Drainage Report Final_V2_Comments.pdf Markup Summary

APPENDIX C – FIGURES

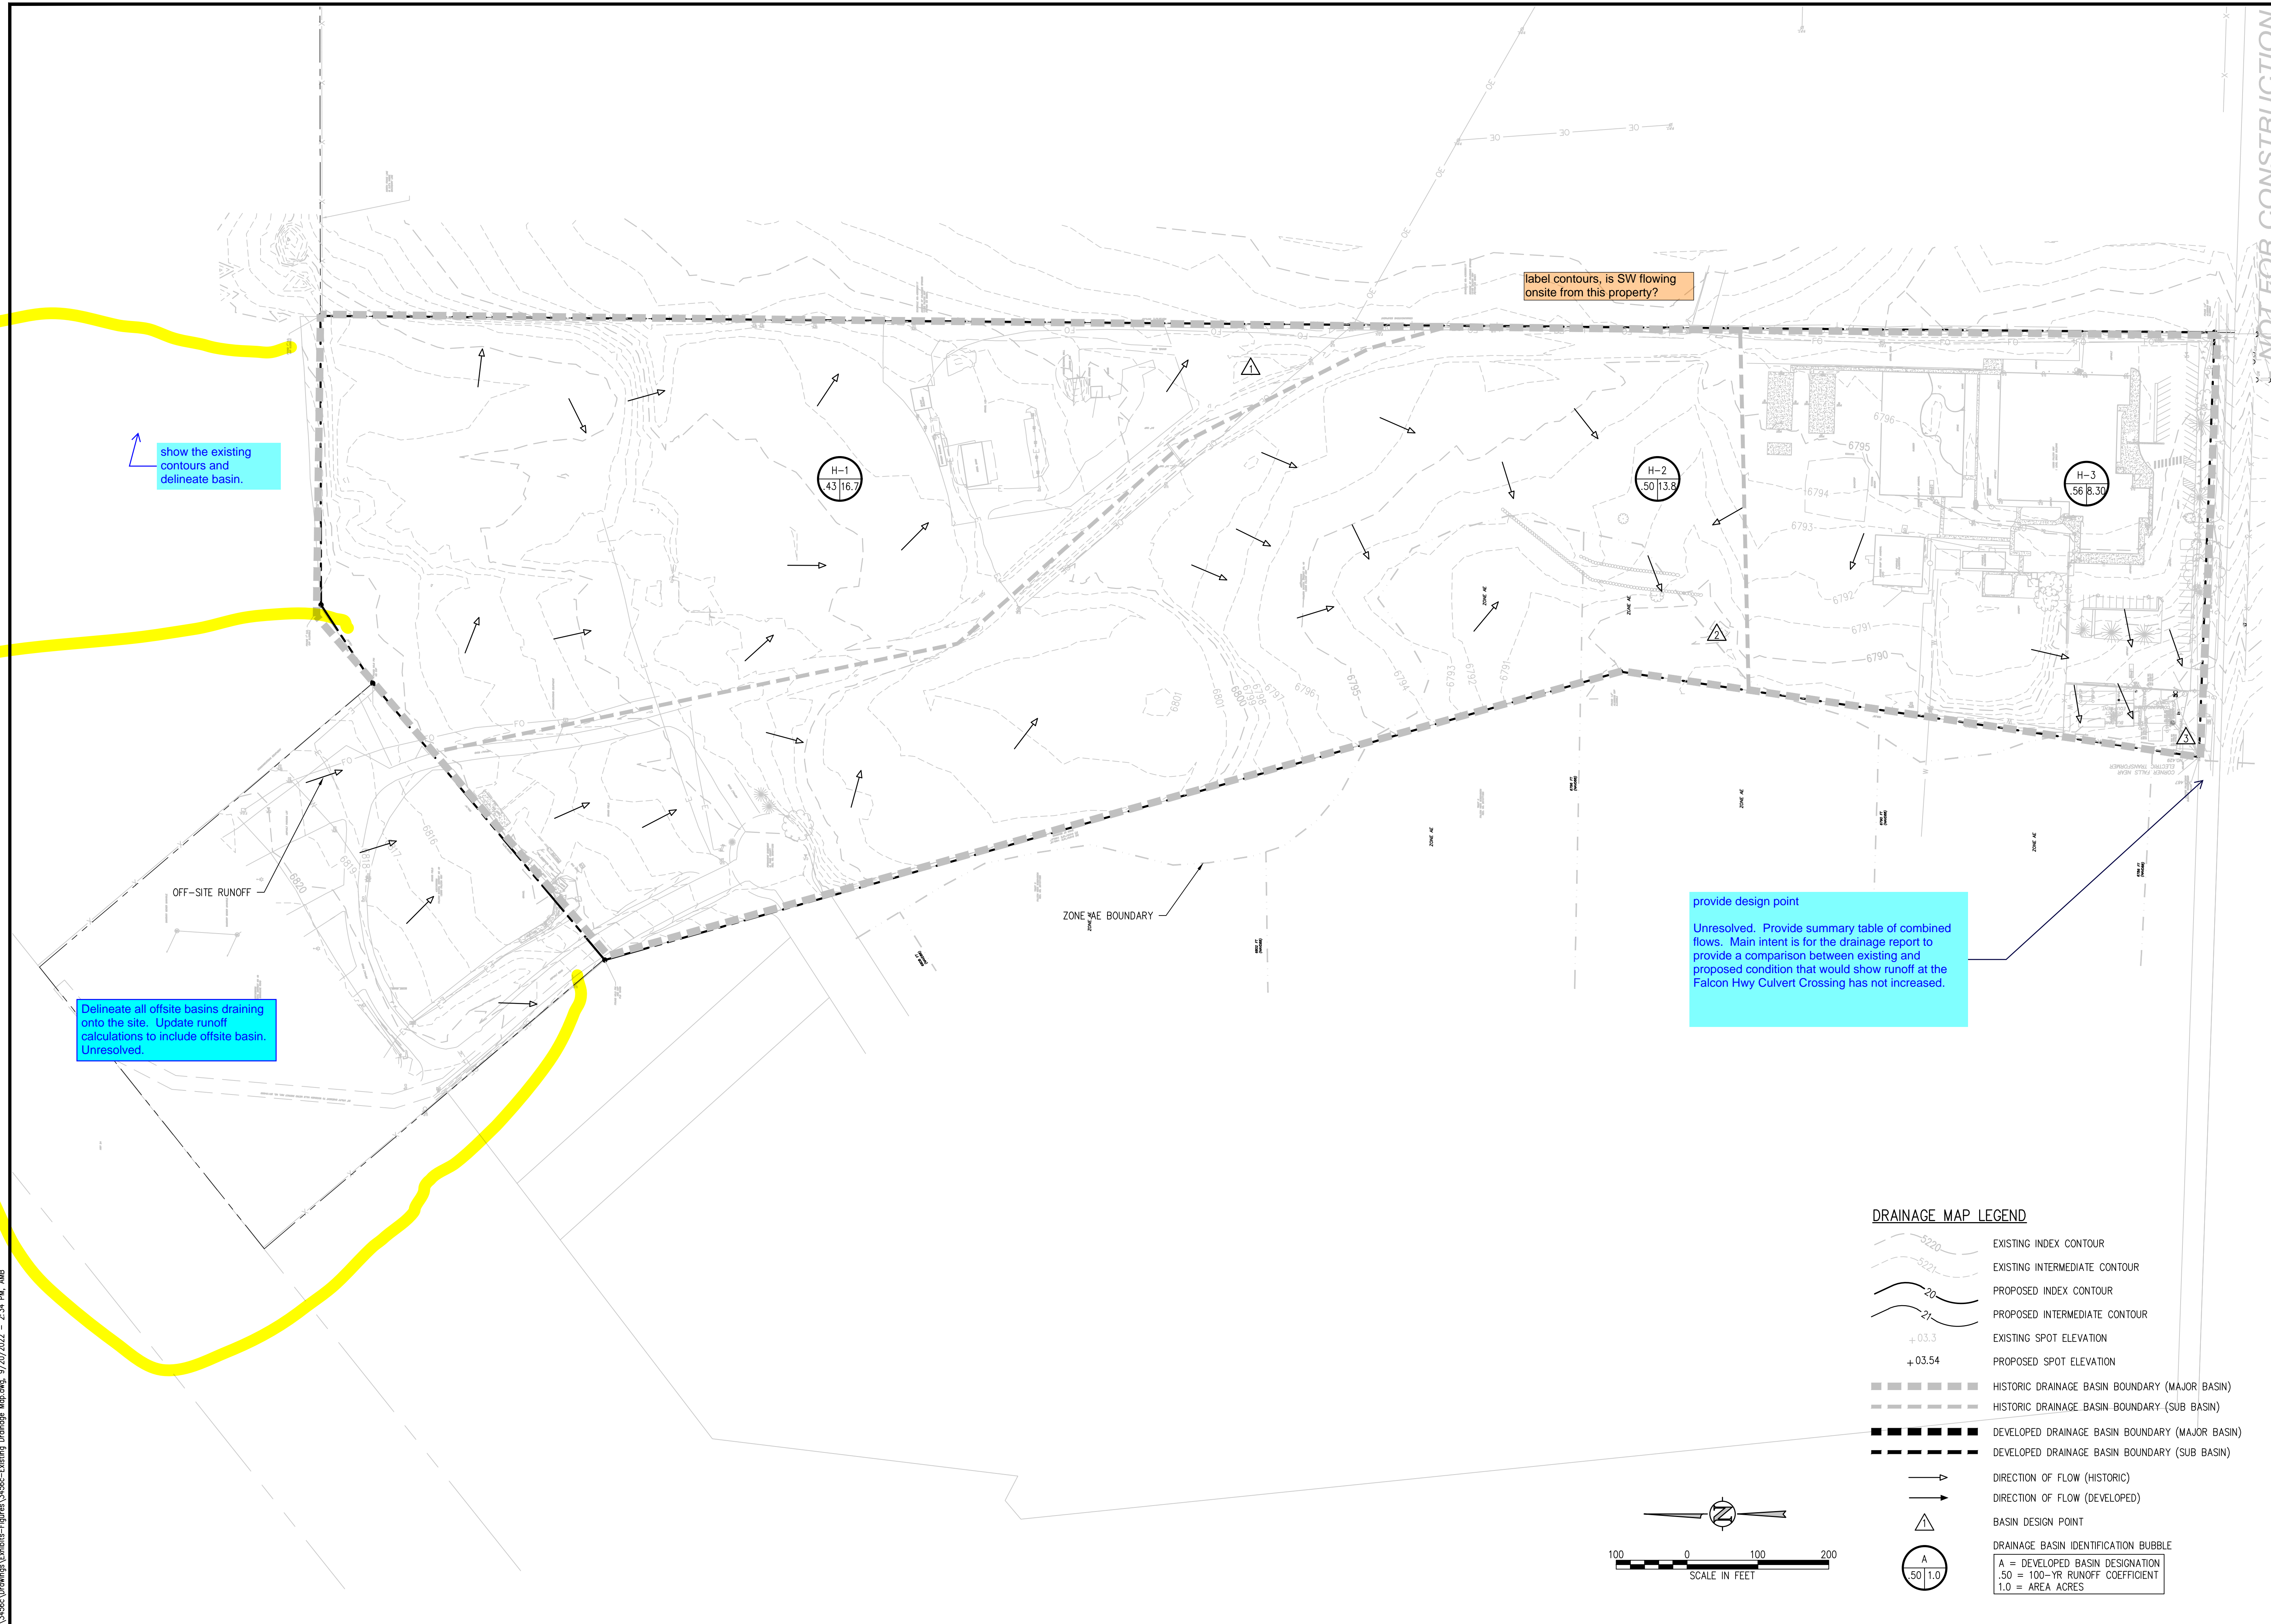
show the existing contours and delineate basin.

show the existing contours and delineate basin.
